Single Family Home lot#23

Captains Landing, Portland, Maine

August 25, 2006

RE: Application for single family house, Captain's Landing

SITE PLAN LOT 23

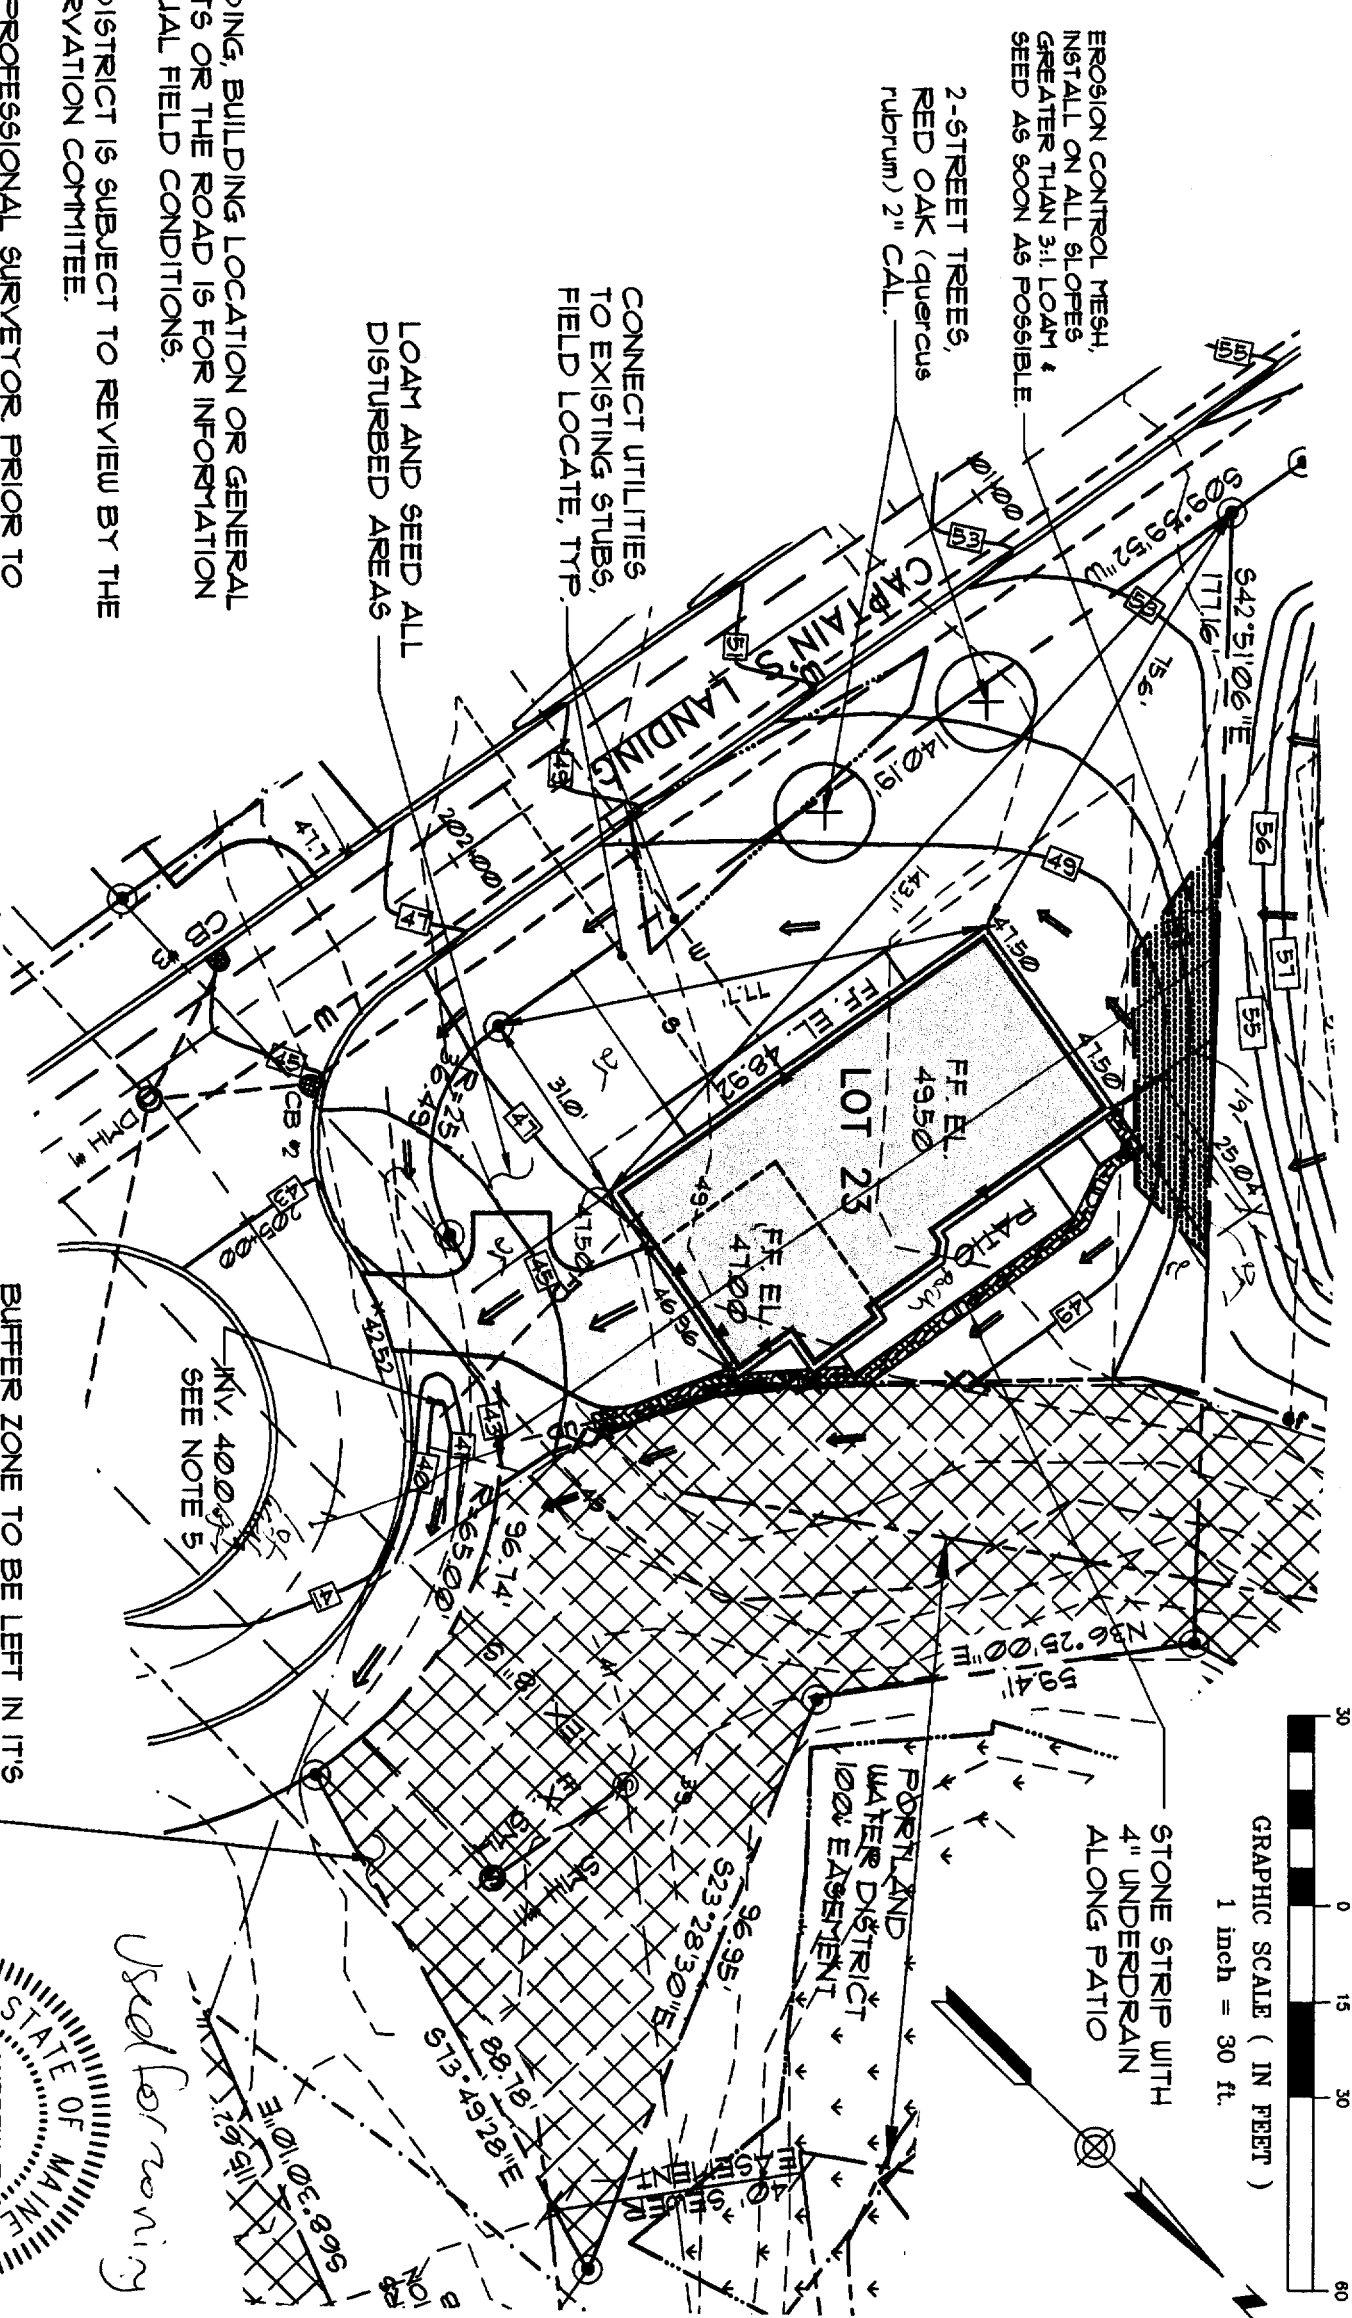
1. Please remove the driveway culvert and associated grading from your site plan. It appears that this feature is not necessary and would only create a drainage concern at #29 Captain's Landing. The lot can be graded to sheet flow drainage to the street effectively.
2. Please note that the construction is shown up against a no-cut buffer zone. Because of the proximity, the City requests that this area be re-surveyed and flagged/staked prior to construction.
3. Also note that any encroachment of the no-cut buffer zone will require a restoration plan approved by the City.

Please resubmit 4 copies of the revised site plan to my attention.
